RE: Oakdale South Industrial Estate exhibition for modification of application (SSD 6917 MOD 1)

We refer to the Department of Planning and Environment's notice of exhibition for the modification application for Oakdale South Industrial Estate (SSD 6917 MOD 1) and respond as follows. TransGrid operates the high voltage transmission line network in NSW. The abovementioned development is subject to the following TransGrid easement and the infrastructure situated therein.

SSD6917 - Oakdale South Industrial Estate, TL: Syd Sth - Syd West No.1 330kV (Fdr 30 Str 10-13 & Fdr 14 Str 110-111)	
Property of Transgrid. No warranty is given that information shown is complete or accurate.		PRODUCED FROM TAMIS	Scale: 1:15000
18/11/2015 15:14:49 Created by: P86665		A4

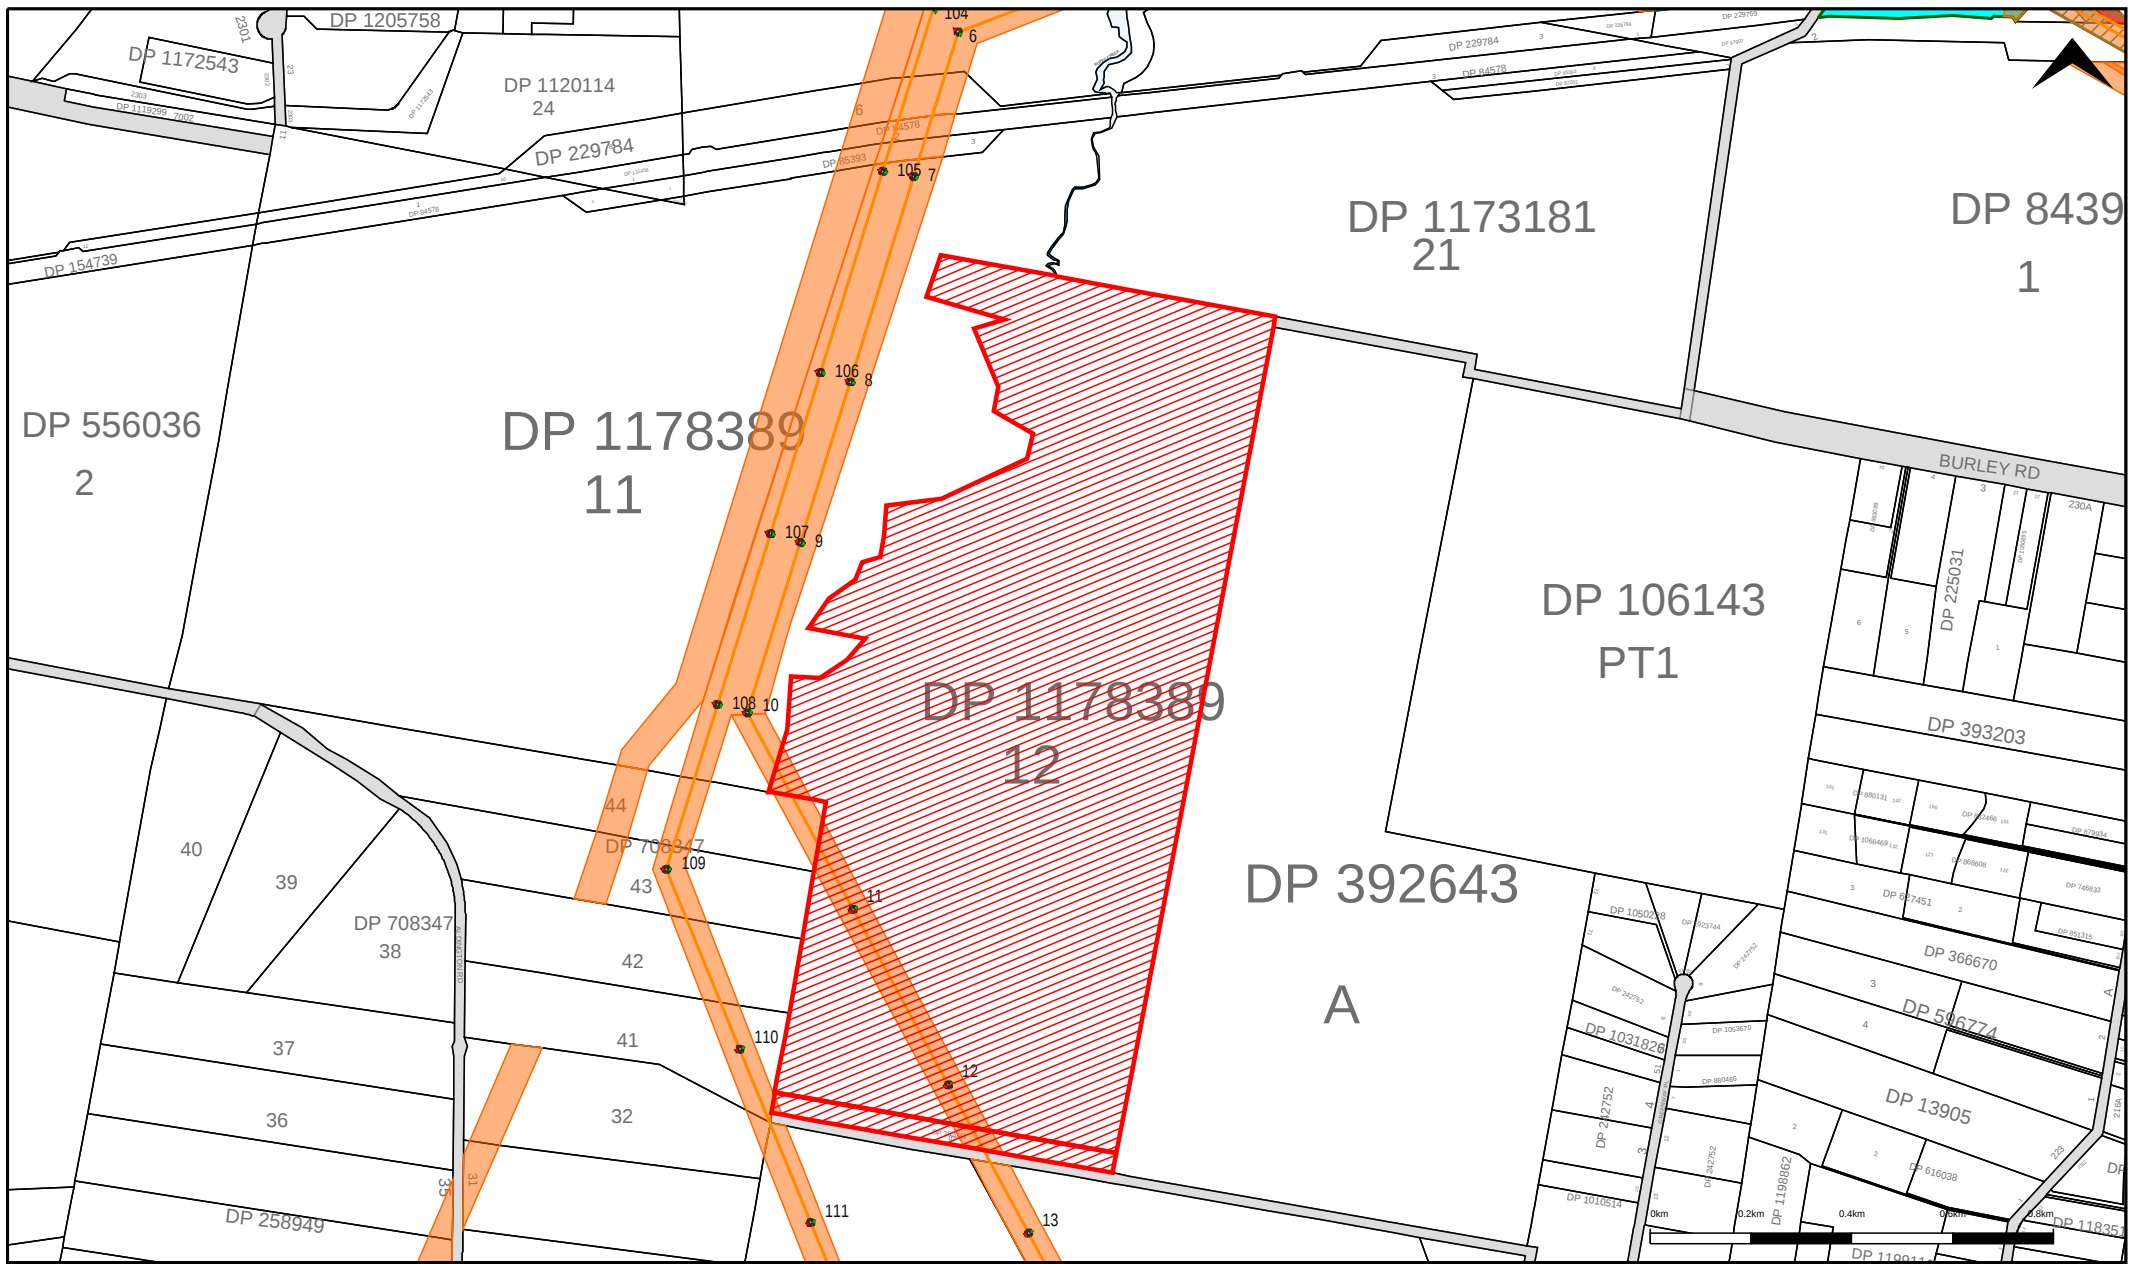
This easement traverses the subject land pertaining to the Oakdale South Industrial Estate within a 60.96m wide easement. Attached is a plan that identifies the approximate position of our easements and infrastructure on or near the subject land, along with a Deposited Plan (DP 1153614) in respect of same.

Where Road No. 1 proposes to encroach TransGrid's easement, our understanding is that the proposed changes to the road are occurring to the east and do not affect TransGrid's easement. TransGrid has no objection to the proposal, conditional upon the road RL's complying with our vertical clearance requirements. These clearances are imposed by TransGrid in the interest of public safety and protection of TransGrid's infrastructure.
